From: Daun Johnson
Sent: 08 March 2022 09:12
To: Planning.Responses
Subject: FW: Planning Consultation on: CM/4/22/DOC - Climping
Attachments: Langford, Climping - Althon Invoice No.17749 (Headwall Grille).pdf; Langford, Climping - Drainfast Invoice No.0008639 (Diffuser Units).pdf; Langford, Climping - Drainfast Invoice No.0009102 (Silt Traps).pdf; Langford, Climping - SEL Environmental Invoice No.22011 (Controflow).pdf; Langford, Climping - Wolseley Invoice No.73939059 (Headwall Units).pdf; Langford, Climping - Wolseley Invoice No.74037321 (Hydrobrake).pdf; Asbuilt Drainage checks Jan22.pdf

Application No: CM/4/22/DOC

Site Address: Langford Horsemere Green Lane Climping BN17 5QZ

Description of Works: Approval of details reserved by condition imposed under ref CM/64/19/PL relating to Condition Nos 8 - as-built drawings and 14 - energy efficiency.

As-built Survey

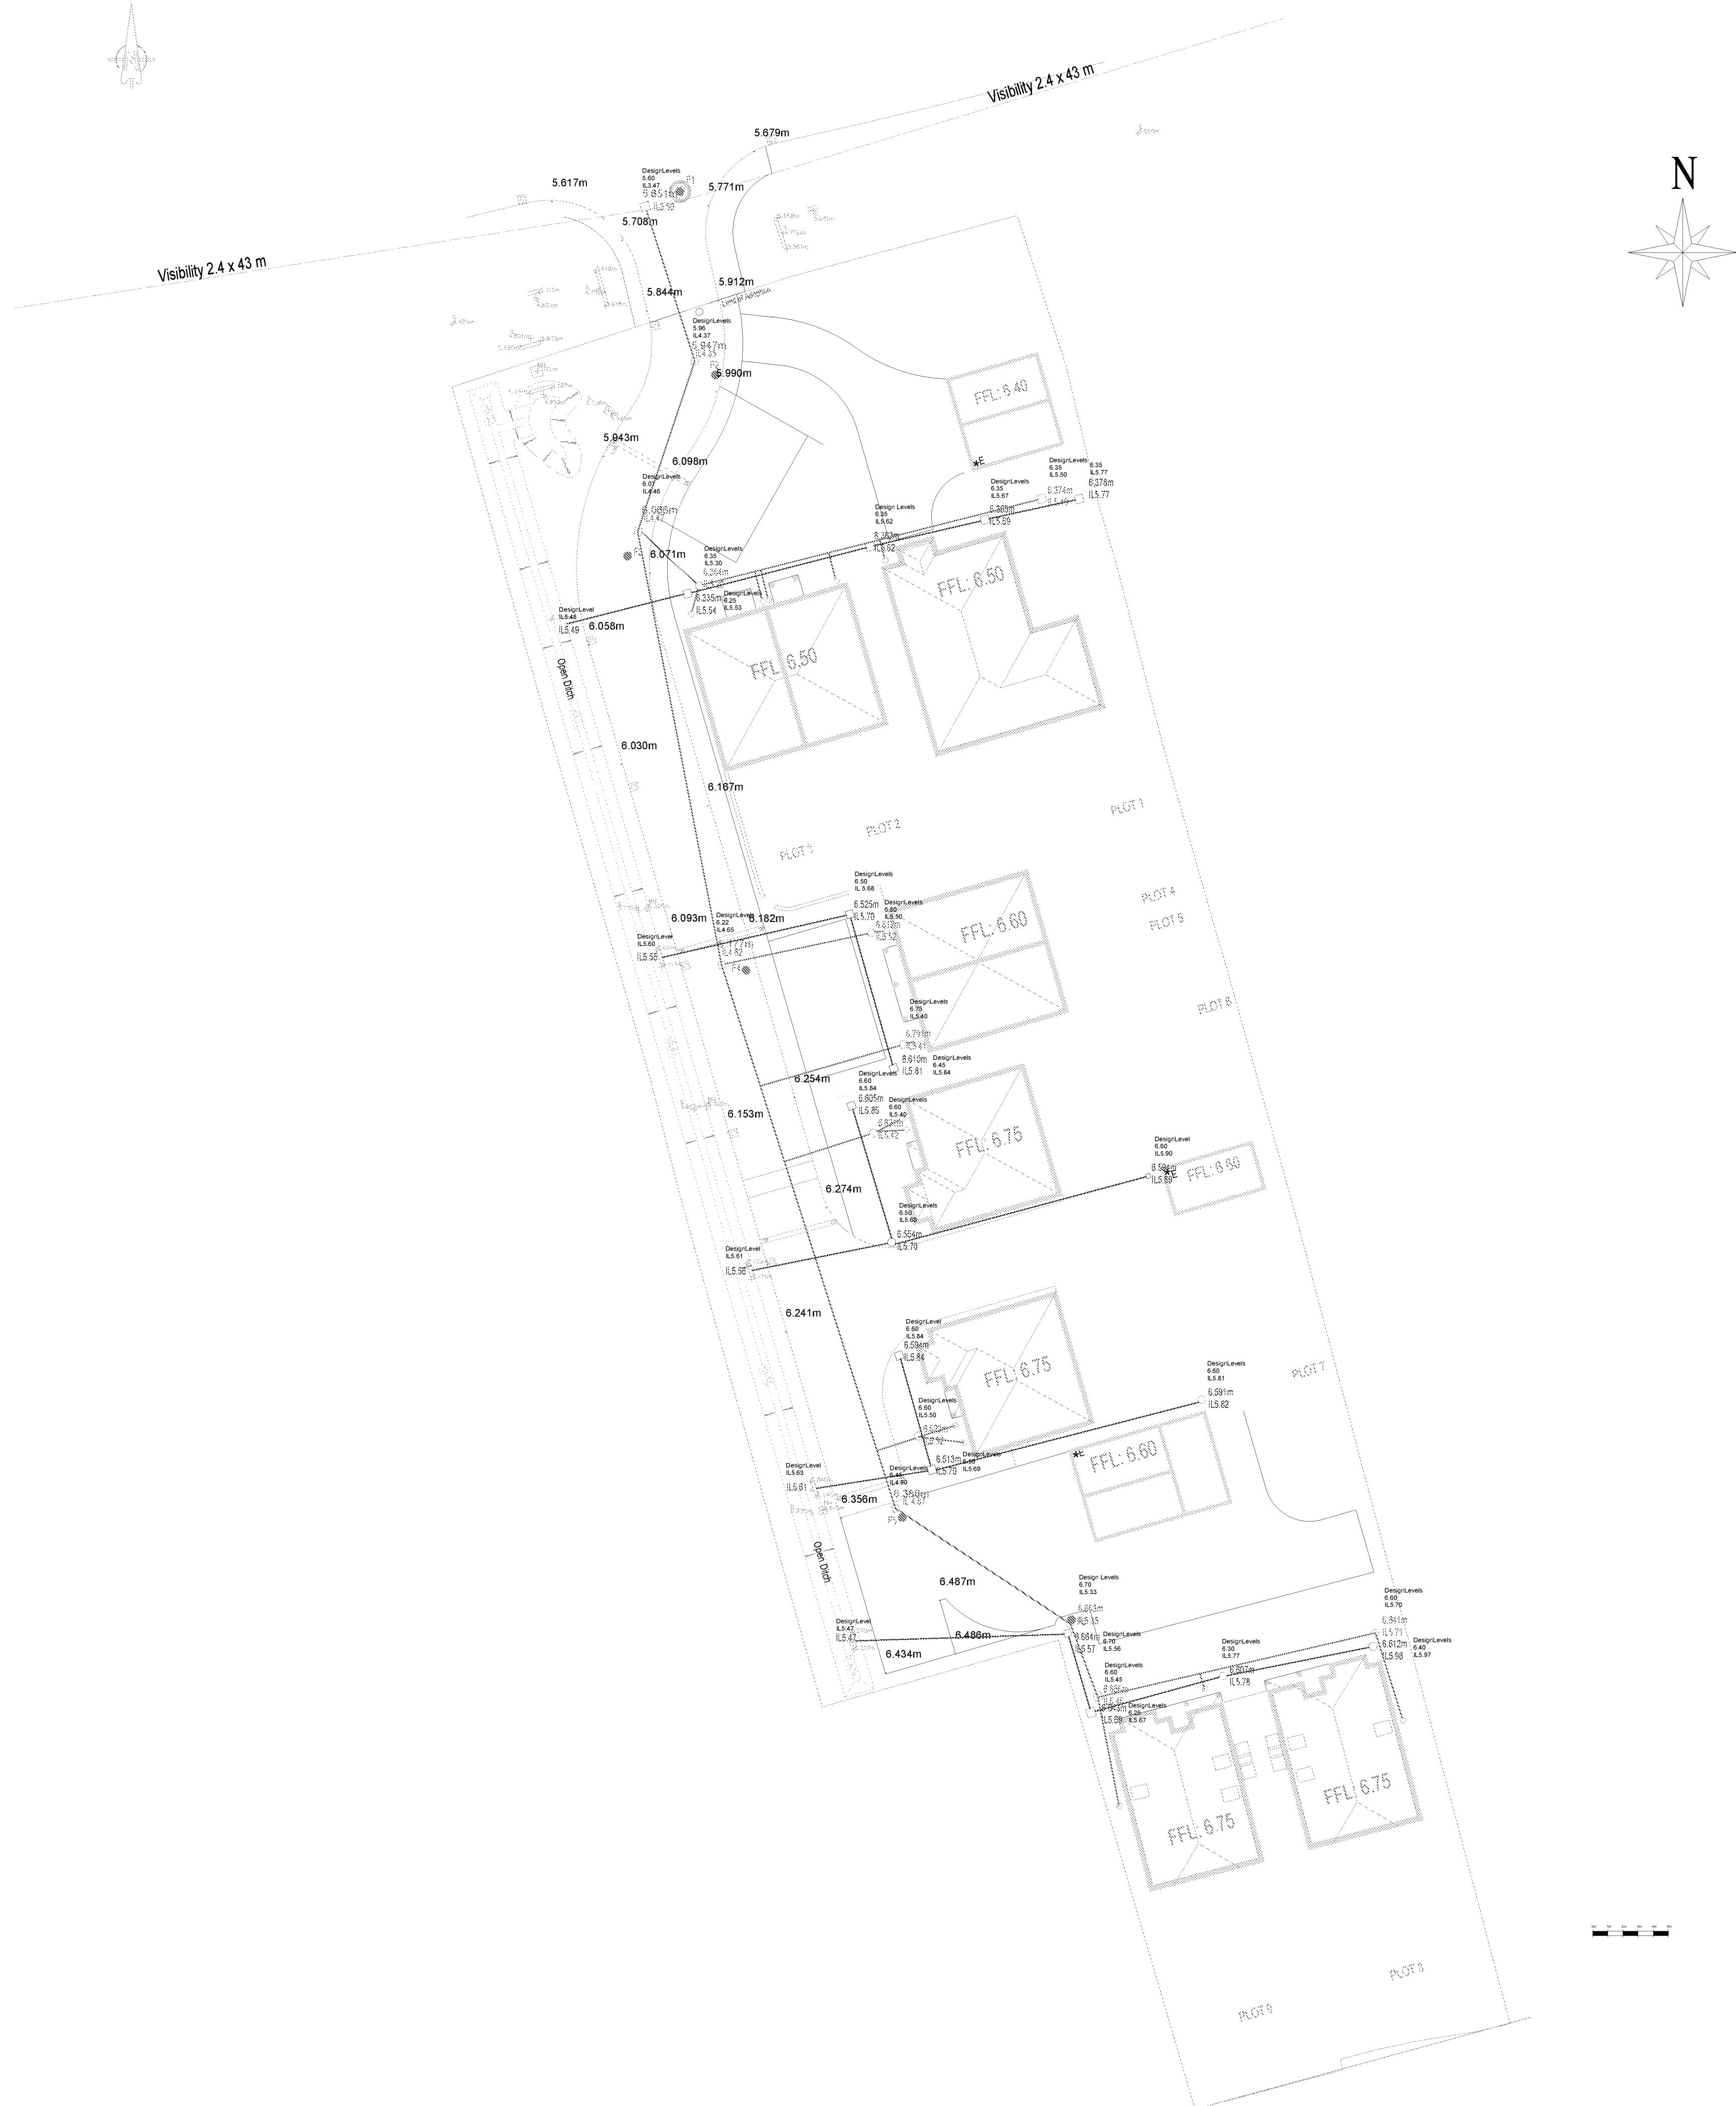
Please provide details of the inspection and verification of control chambers. I.e. surveyed invert and cover levels and good receipts for flow control devices.

- Additional survey data (Asbuilt Drainage Checks Jan22.pdf), which now identifies surveyed cover and invert levels.
- Invoices for SuDS flow control features
